Case Officer: Gemma Magnuson**Recommendation:** Refused**Applicant:** Signal Infrastructure UK Limited**Proposal:** Proposed telecommunications installation: Proposed 15.0m Phase 9 slimline Monopole and associated ancillary works**Expiry Date:** 14 May 2023**Extension of Time:**

2.1. The application seeks prior approval for the erection of a 15 metre tall phase 9 monopole and associated ancillary works upon the verge. Ancillary works would consist of the erection of cabinets and the laying of paving slabs on the ground to provide hard-surfaced access to the cabinets and monopole. The colour of all equipment would be fir green.

PROPOSED SITE PLAN

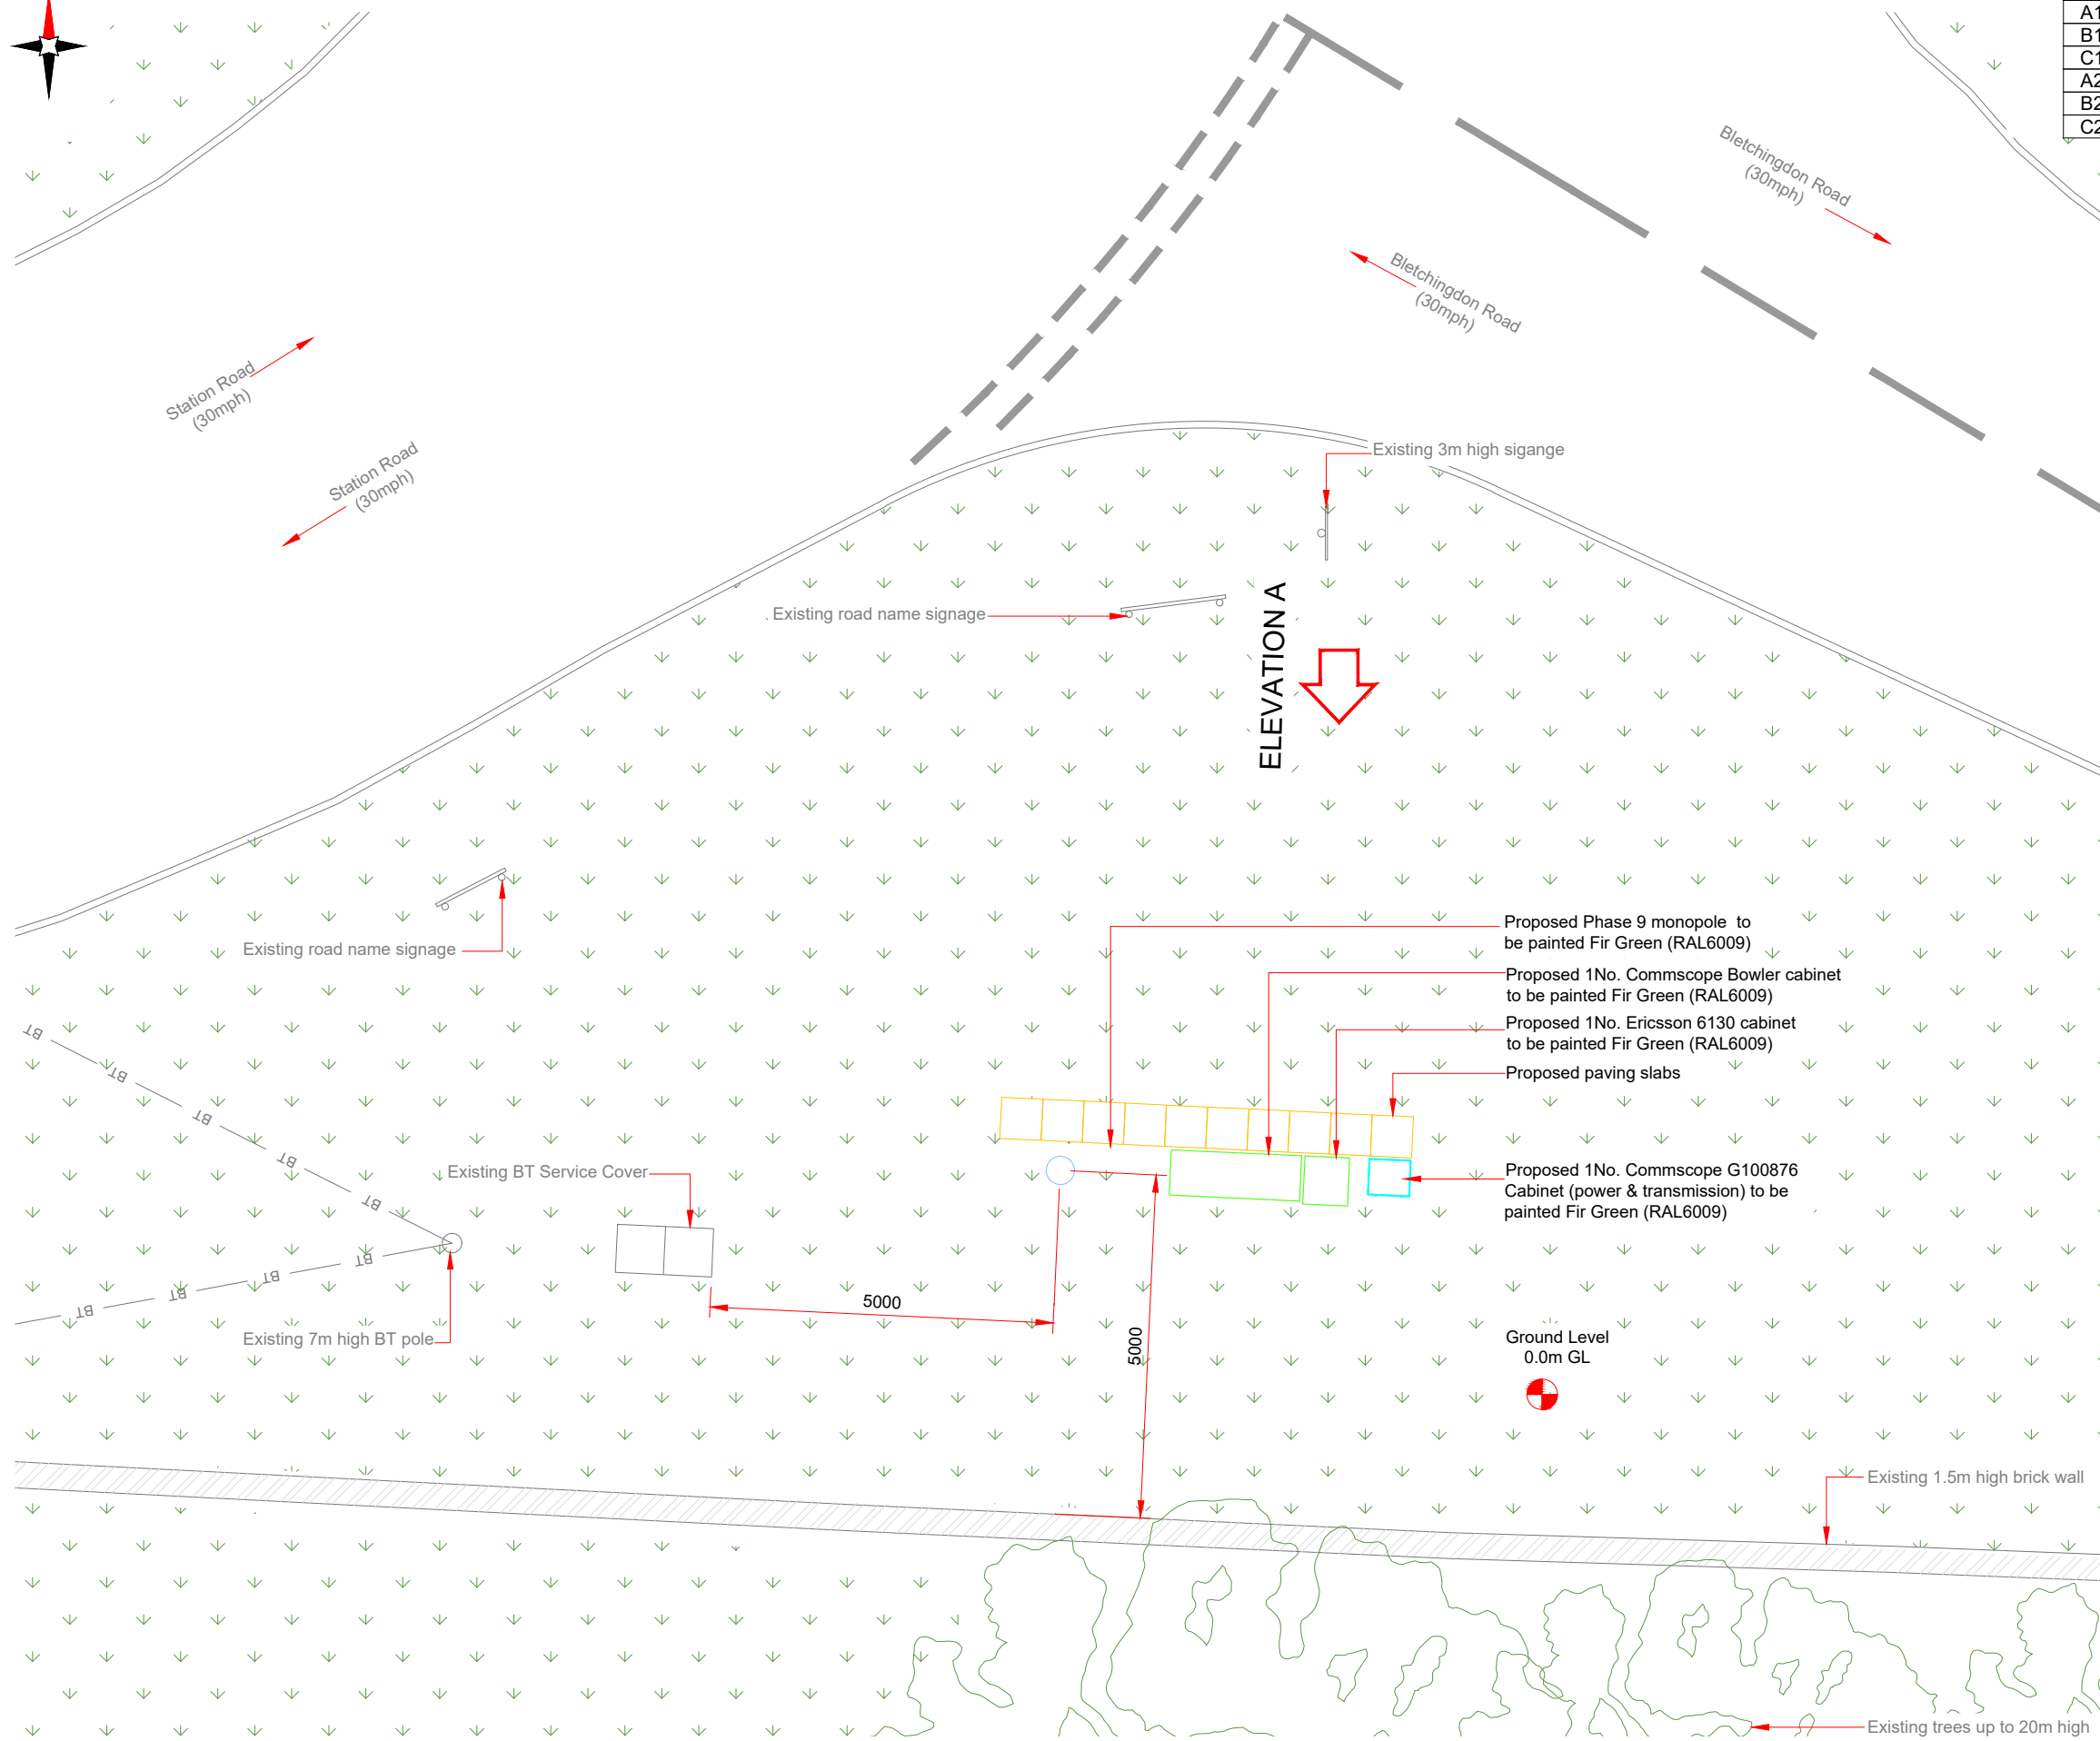
The proposed monopole and associated ancillary works, by virtue of their design and siting would result in less than substantial harm to the character and appearance of the Kirtlington Conservation Area. The public benefits arising from the scheme are not considered to outweigh the harm identified and the proposal is therefore contrary to Policies PD4 and PD5 of the Mid-Cherwell Neighbourhood Plan, Policy ESD15 of the Cherwell Local Plan 2011-2031 Part 1, Policies C28 and C39 of the Cherwell Local Plan 1996 and Government guidance contained within the National Planning Policy Framework.

PROPOSED ELEVATION

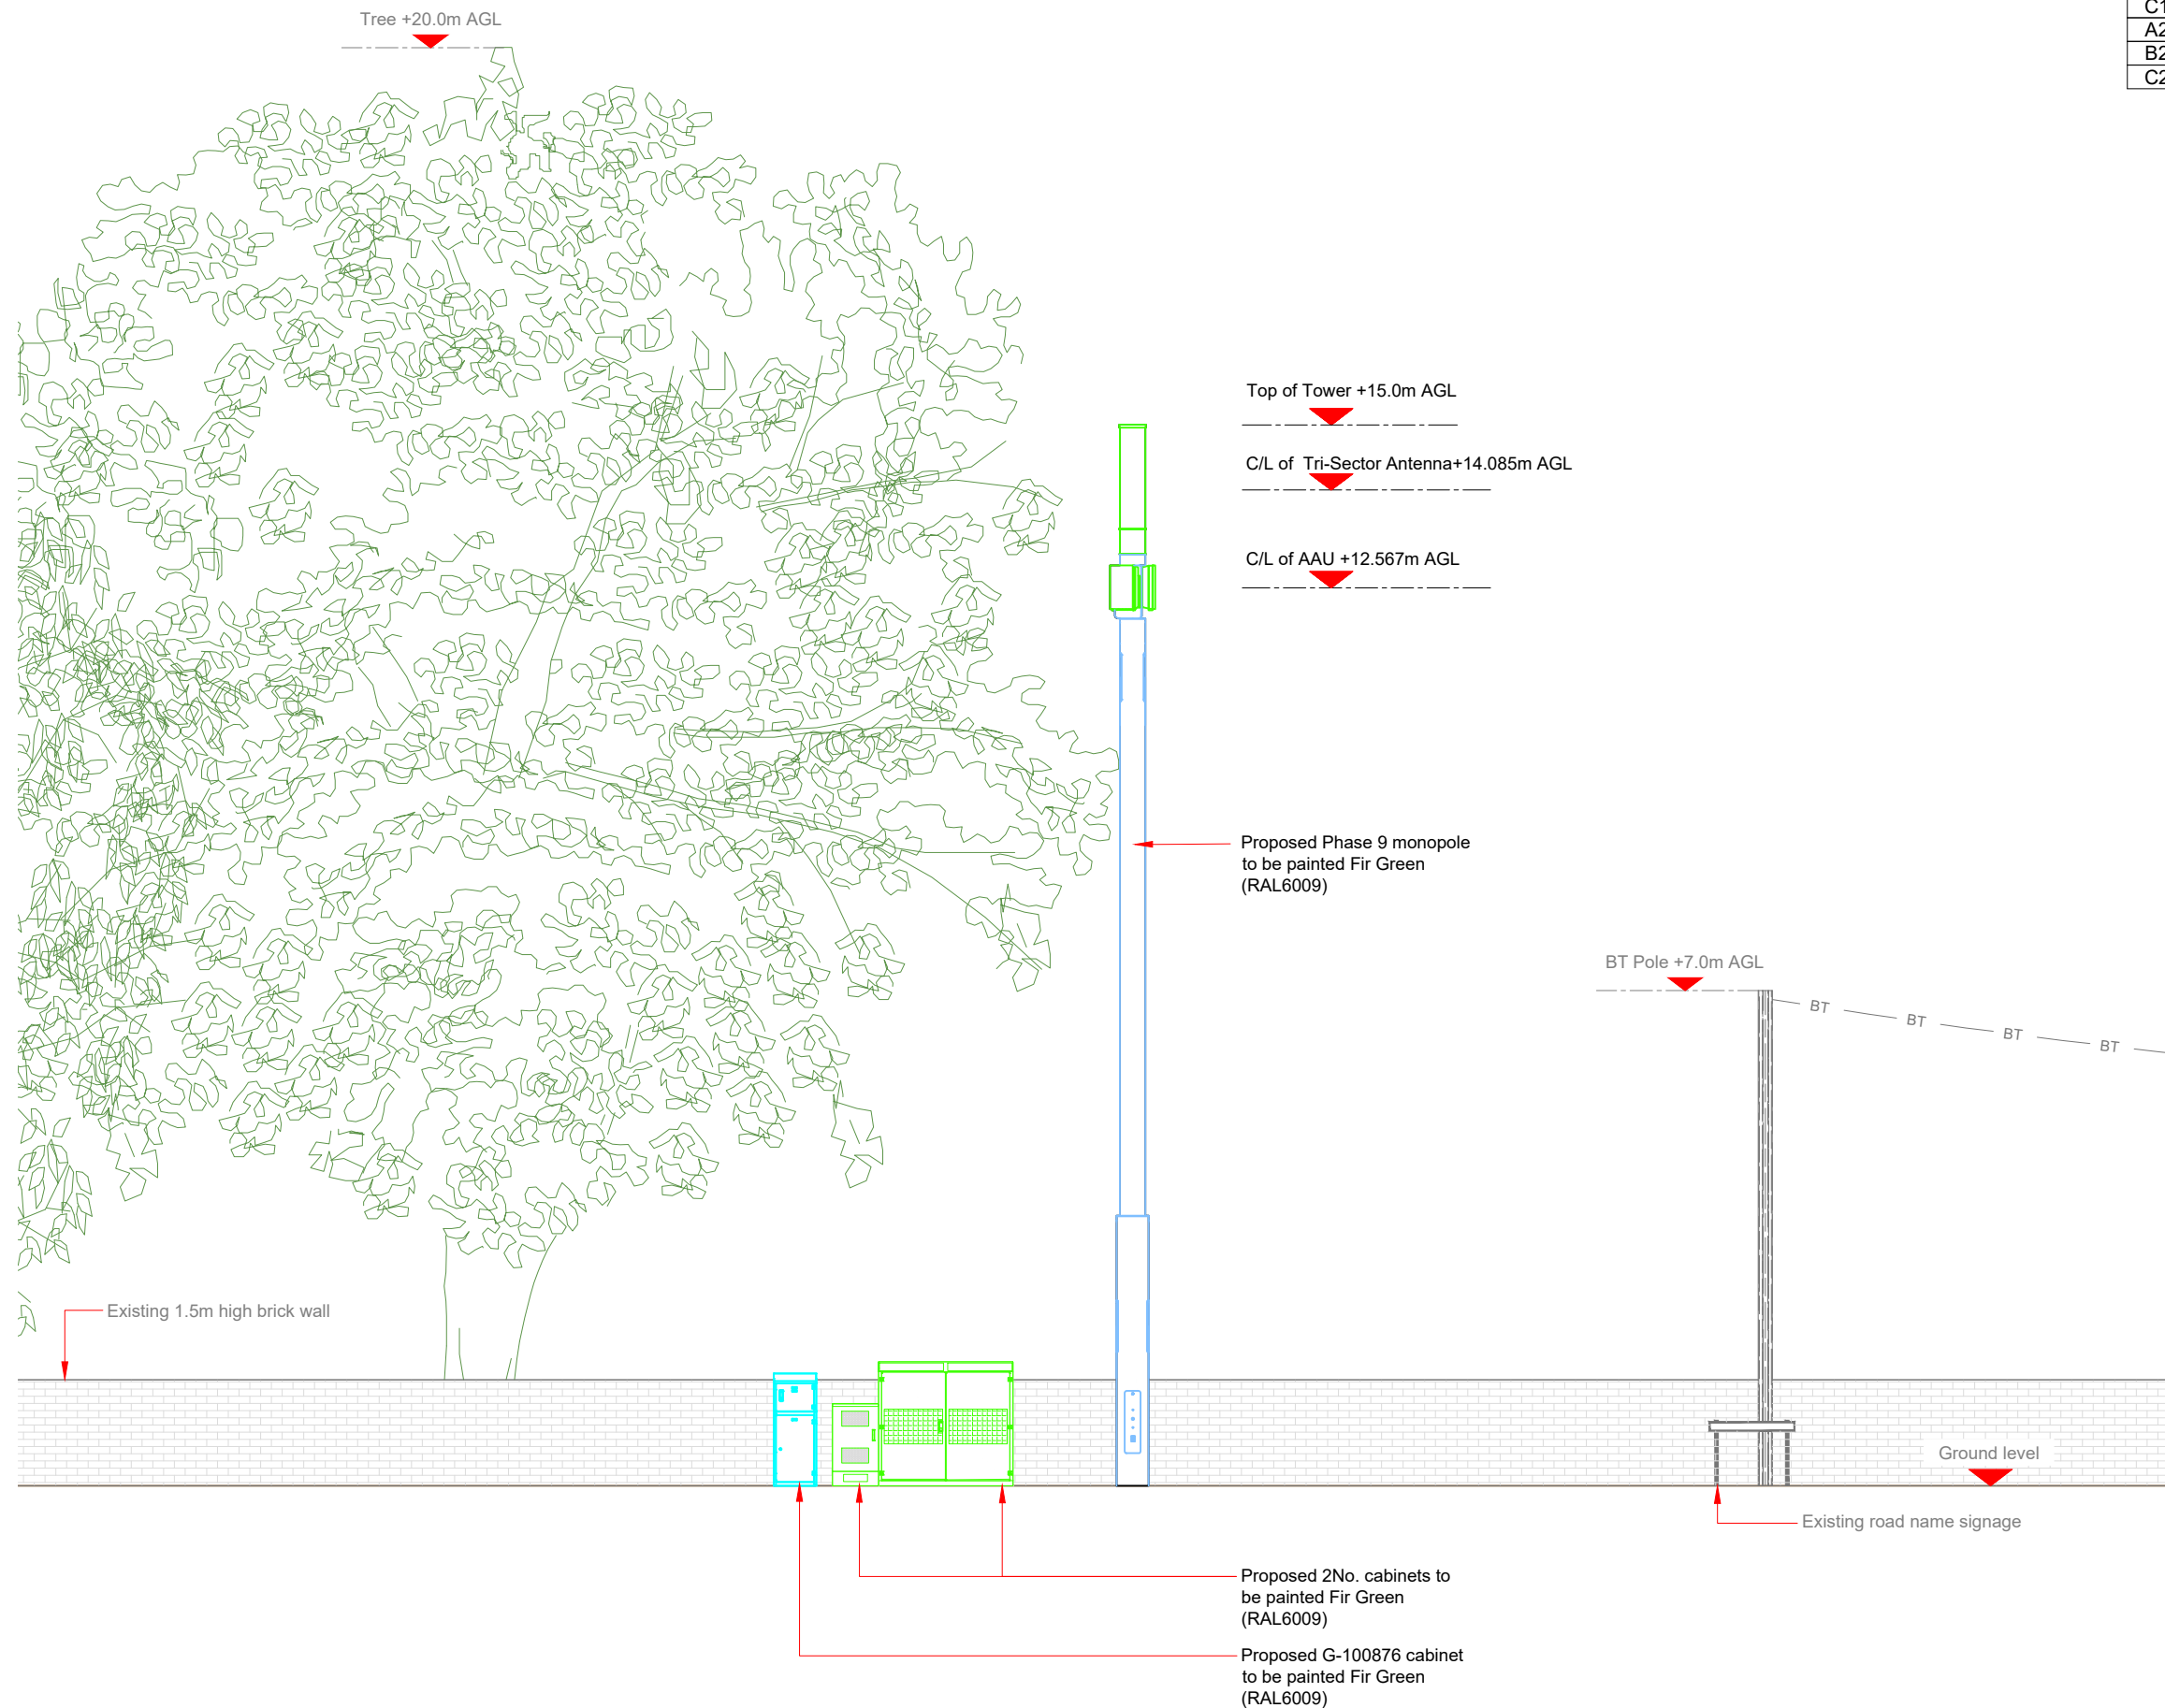
- 8.12. The monopole proposed as part of the current scheme would be of a slimmer design, omitting the wraparound cabinet at the base and finished in a fir green colour. Whilst this would represent an improvement on the previously refused scheme, I do not consider that the amendments go far enough to address the concerns raised by previous Case Officers and the Inspector. In the Appeal decision the Inspector commented as follows:

- 8.15. The height of the proposed monopole remains as previous, and whilst the design is slimmer, particularly the antenna at the top of the monopole, it is considered that the monopole would continue to represent an incongruous and dominant feature within the streetscene, detracting from the character and appearance of the area and resulting in less than substantial harm to the historic significance of the designated Conservation Area.
